Rezoning Transportation Analysis

Petition Number: 2023-024

From: Jake Carpenter, PE
Jacob.carpenter@charlottenc.gov
980-221-5675

Date	Description
06-28-23	First Review (TM)
08-23-23	Second Review (ME)

SHEET NUMBER
RZ-2

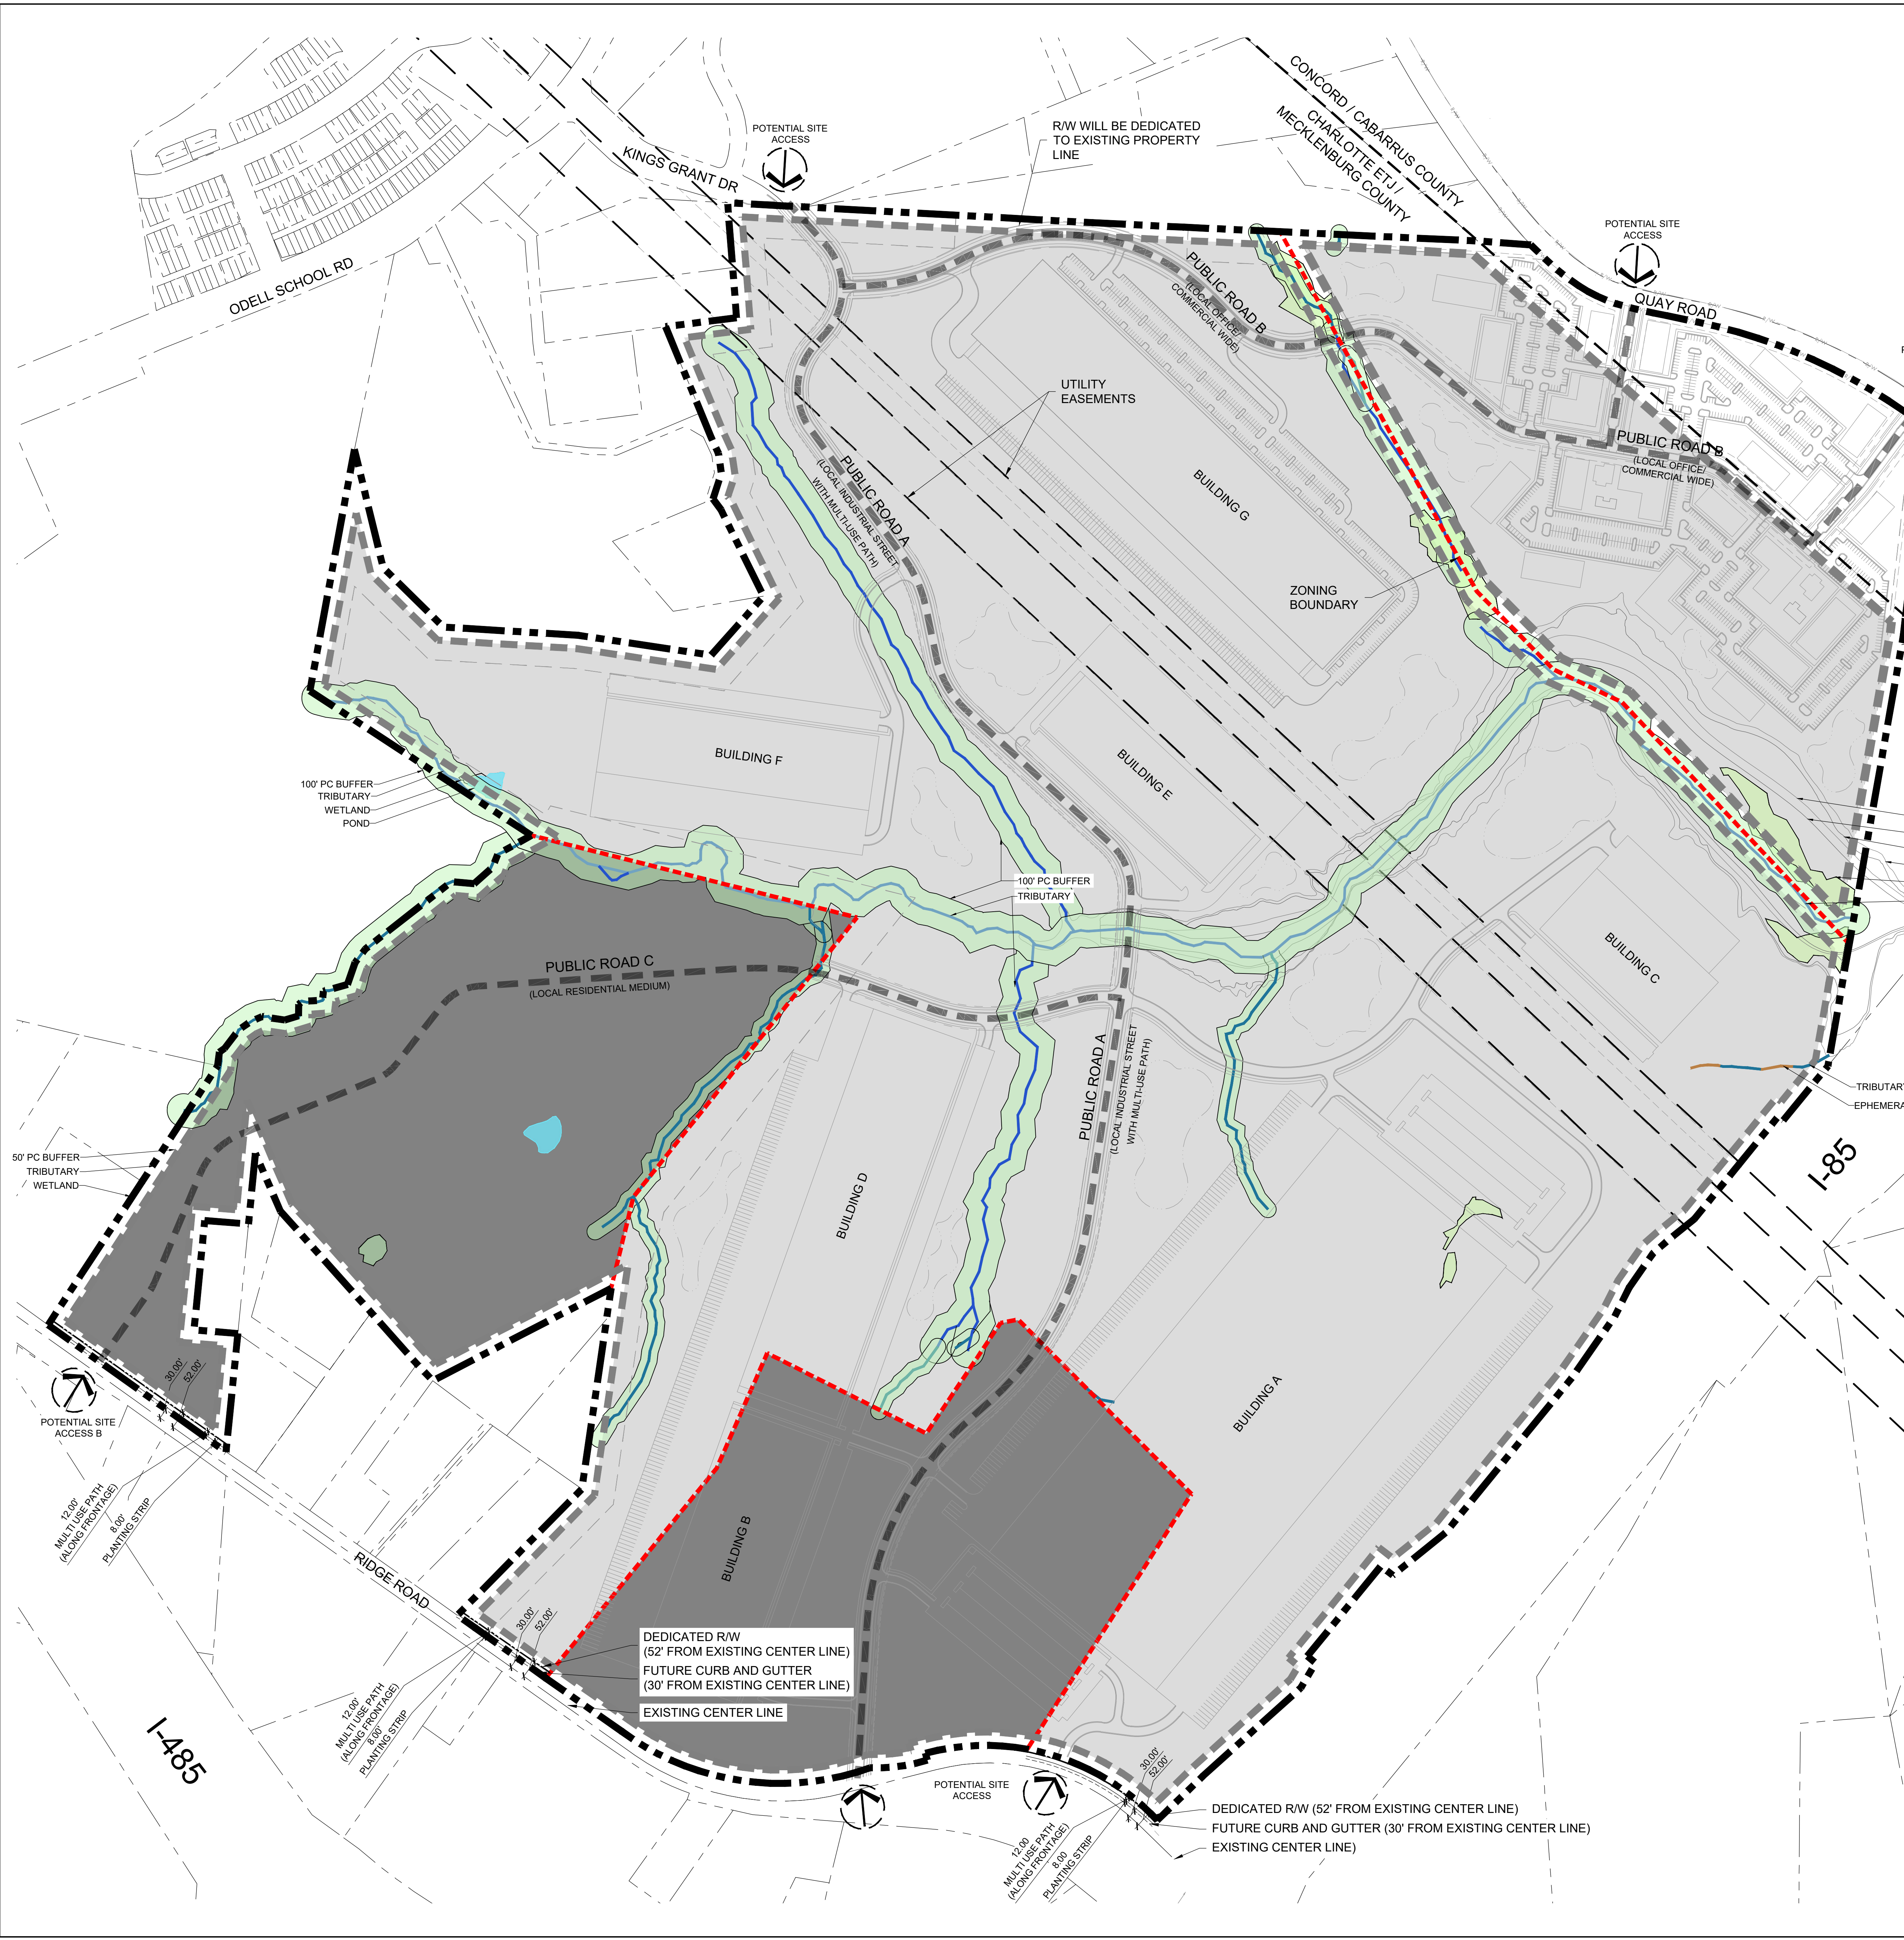
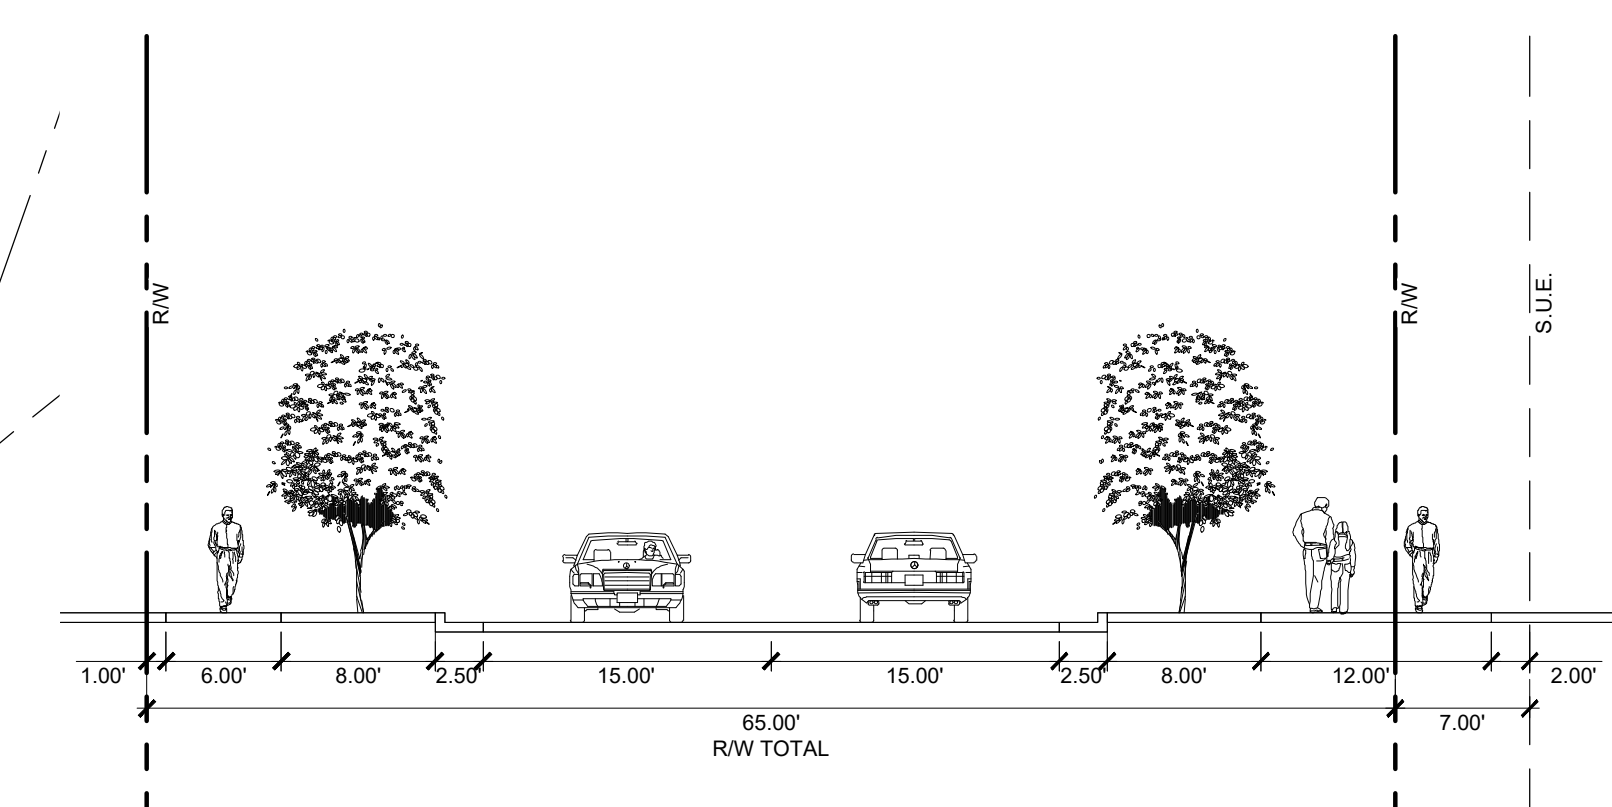
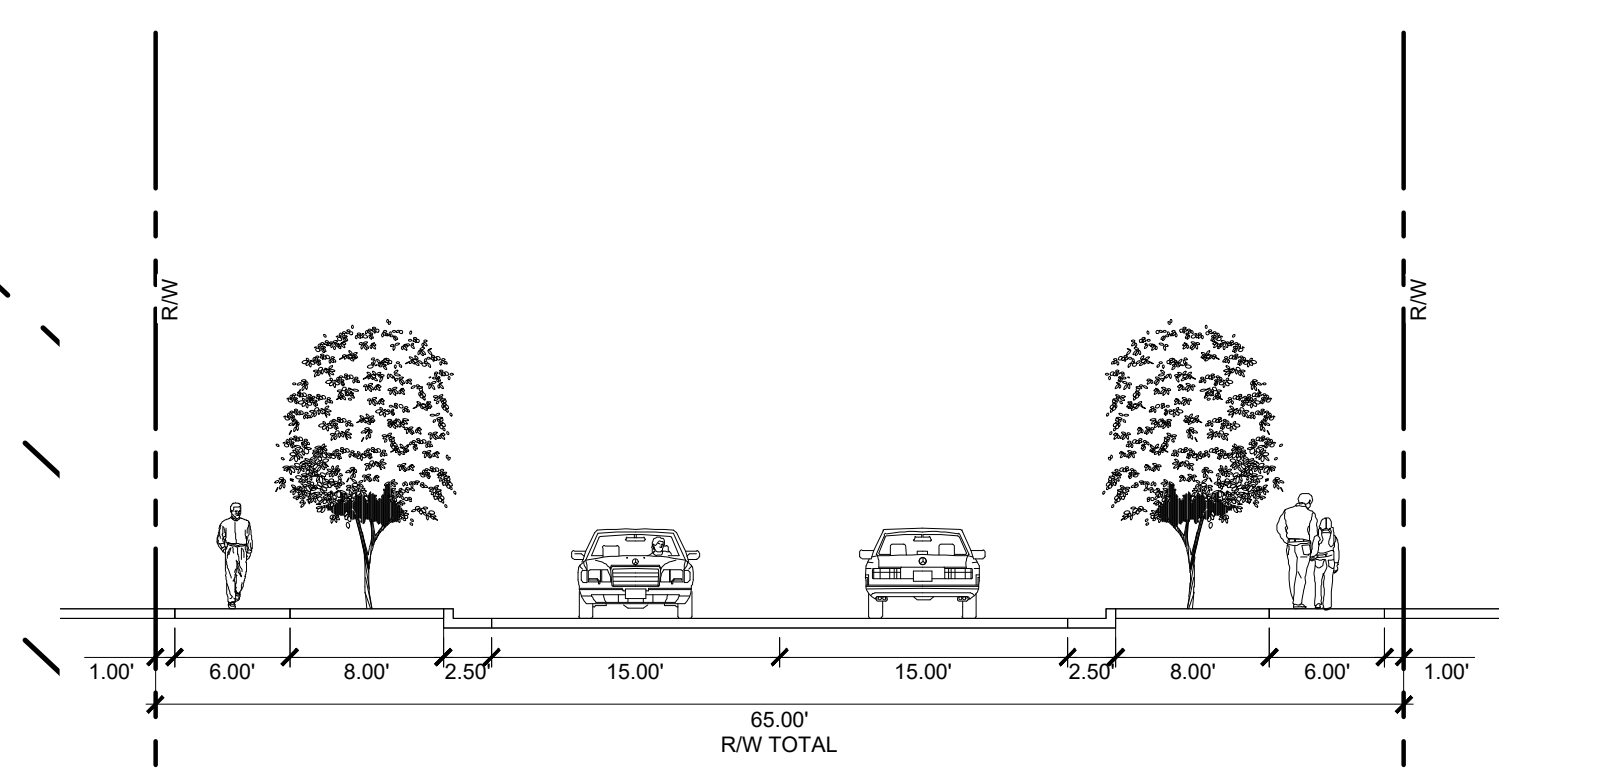
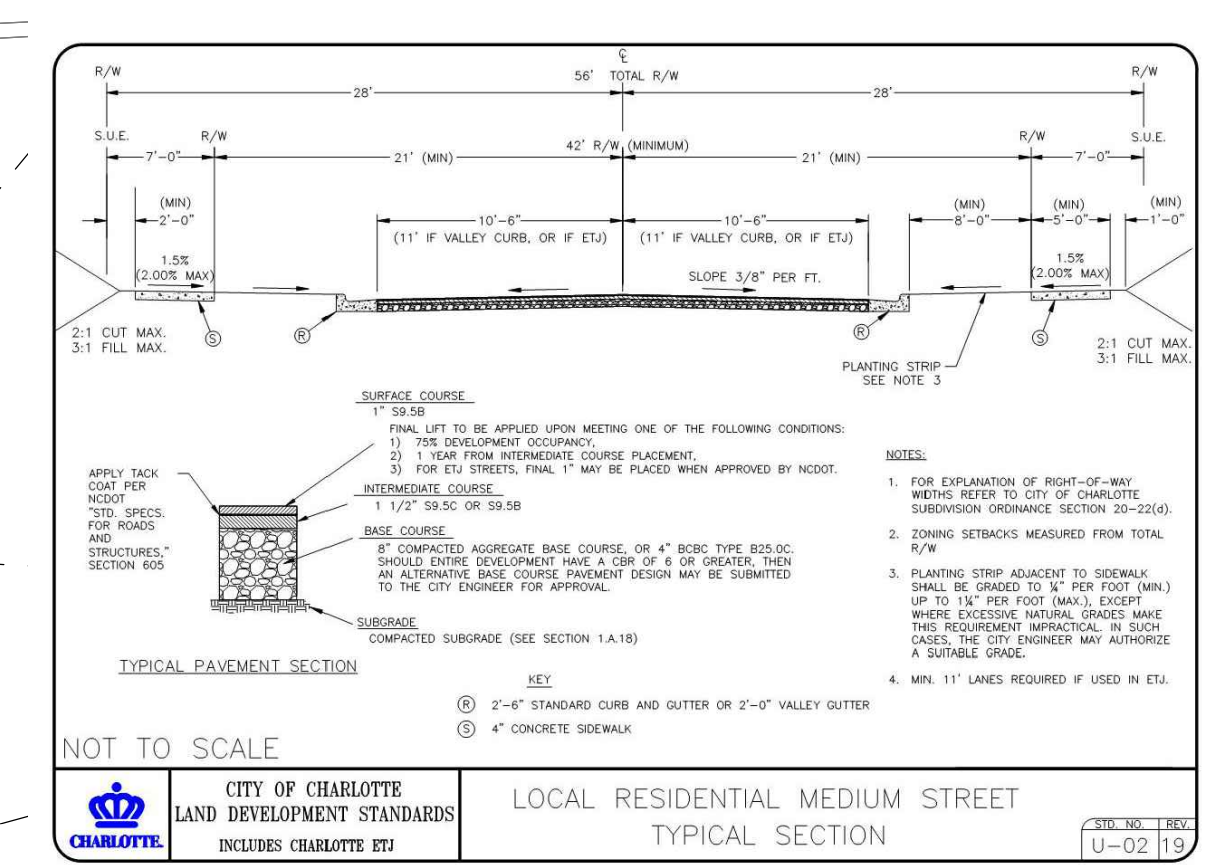
~~3. Revise site plan and conditional note(s) to commit to coordinating internal street network with rezoning 2023-018. Site plan shall show connection locations between rezonings.~~
